**ADC Planning Consultation
Response from the Conservation Officer**

Application Number	BE/74/14/HH
Address	Randall Cottage 111 North Bersted Street Bersted PO22 9AF
Description	Restoration and reuse of outbuilding. This application affects the character and appearance of the North Bersted Conservation Area.
Case Officer	Mrs. J Chapman

**PROPOSED  
GROUND FLOOR PLAN**  
Scale: 1:50 @ A3  
May 2014  
**1413-101a**

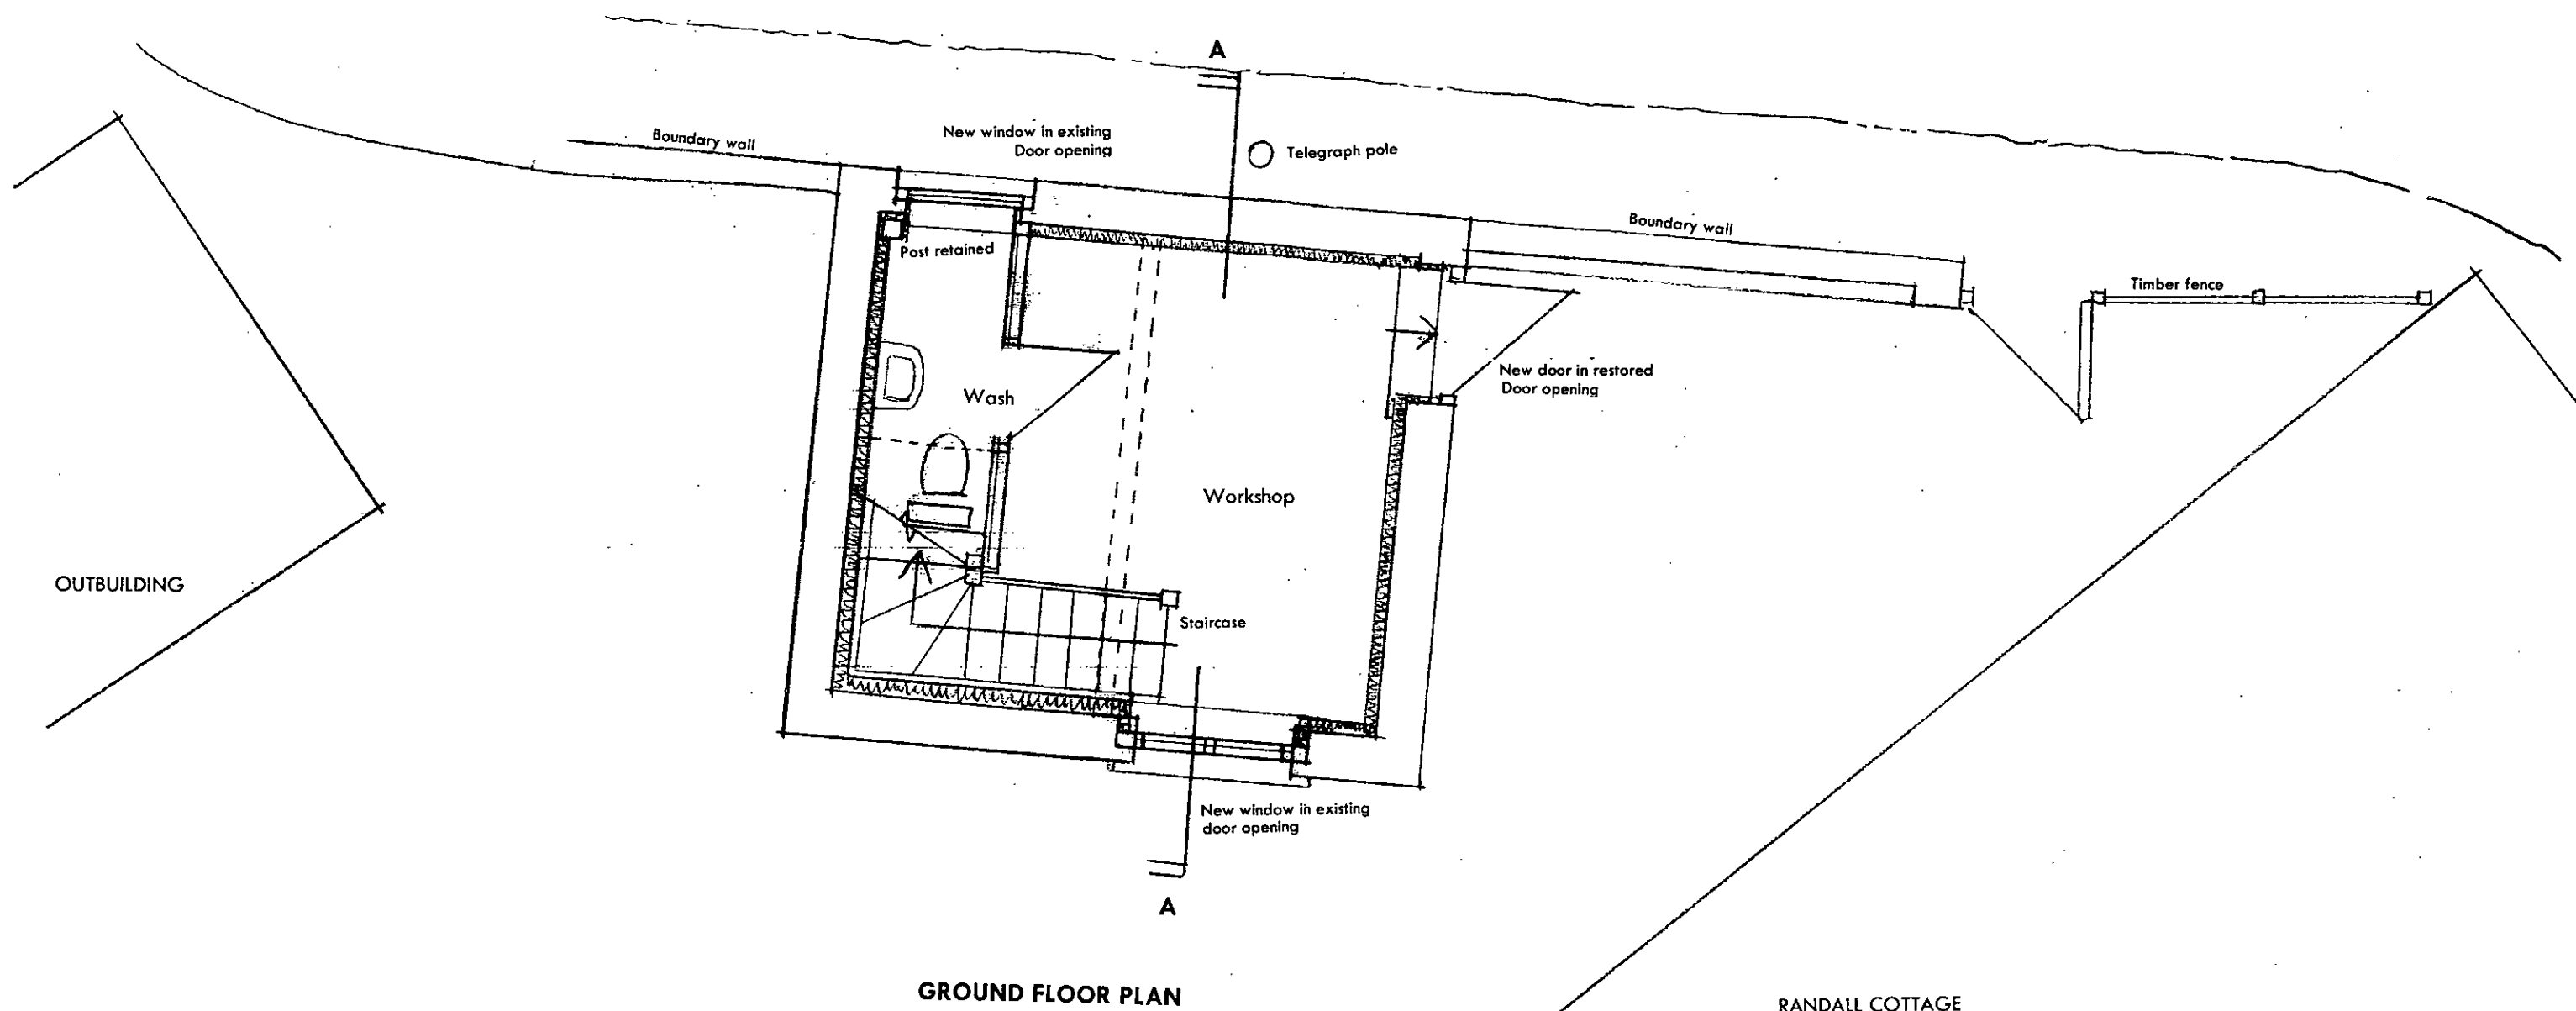
Further information will need to be provided with regards the external timber joinery (windows and doors). Further, the roof-lights should be of conservation standard.

- Details of the windows and doors
- Conservation standard roof-lights
